**KIRKLEES METROPOLITAN COUNCIL  
INVESTMENT & REGENERATION SERVICE**

**DELEGATED DECISION TO DETERMINE APPLICATIONS FOR  
CONSENT, AGREEMENT OR APPROVAL REQUIRED BY CONDITION**

Reference No:	<b>2023/44/92120/E</b>
Site Address:	West Yorkshire Fire & Rescue Service, Oakroyd Hall, Bradford Road, Birkenshaw, BD11 2DY
Description:	Discharge of condition 7 (materials) of previous permission 2022/92681 for variation conditions 2 (plans), 3 (CMP), 4 (LEDS), 8 (BEMP) 12 (Drainage), 17 (AMS), 22 (Phase II Intrusive Investigation) & 23 (Remediation) on previous permission 2022/91138 for demolition of existing training centre and occupational health buildings, erection of new headquarters including indoor training centre, extension of existing building to form new fire station, extension of car parking and associated landscaping and drainage
Recommending Officer:	Louise Bearcroft

**Discharge of condition 7 (materials) of previous permission 2022/92681 for variation conditions 2 (plans), 3 (CMP), 4 (LEDS), 8 (BEMP) 12 (Drainage), 17 (AMS), 22 (Phase II Intrusive Investigation) & 23 (Remediation) on previous permission 2022/91138 for demolition of existing training centre and occupational h

Fire Station Elevations - Material Locations

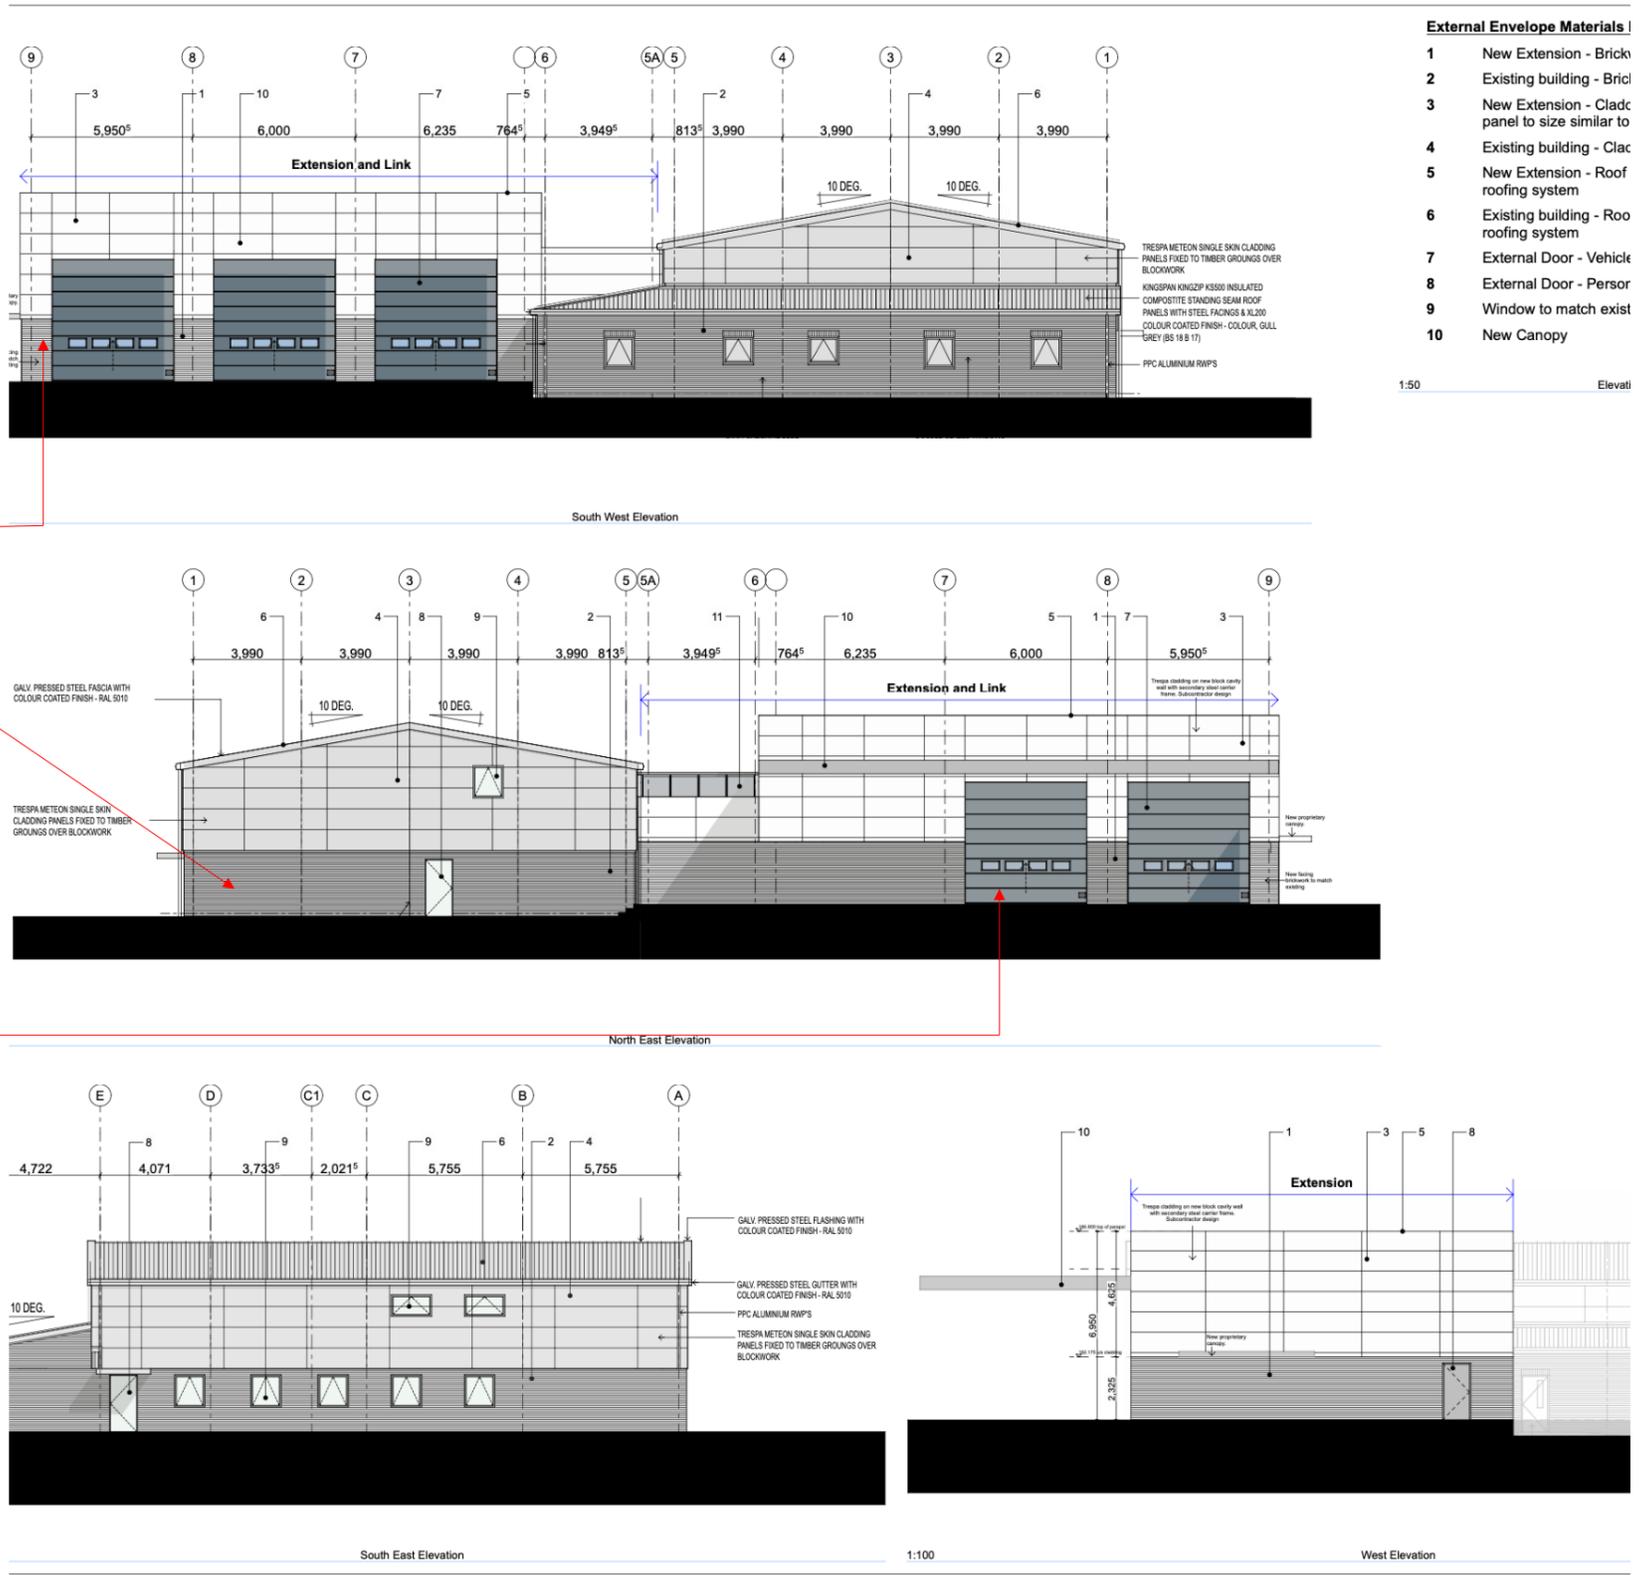
Officers sought some minor points of clarification, namely whether the image of Staffordshire Blue Brick with Charcoal Mortar is correct in the schedule, as it appears pale in colour, as well as confirmation of which doors would be coloured Flame Red (RAL 3000) this colour being shown but not referenced in the text, and not clearly marked on the elevation drawings.

- *The mortar and brick samples were both taken on site on a bright sunny day so may appear brighter. Please see attached image of brick next to existing brick on the other existing buildings for comparison. In the image the brick to the back of the photo is the brick on the existing building (highlighted on the map attached) known as the TRTC building*

*which is situated on the corner between the A651 and Whitehall Road West. The brick in front is sample of the proposed for the HQ training arena.*

- *The station doors on page 13 elevation plan of the submitted document should be coloured in as Flame Red RAL 3000.*
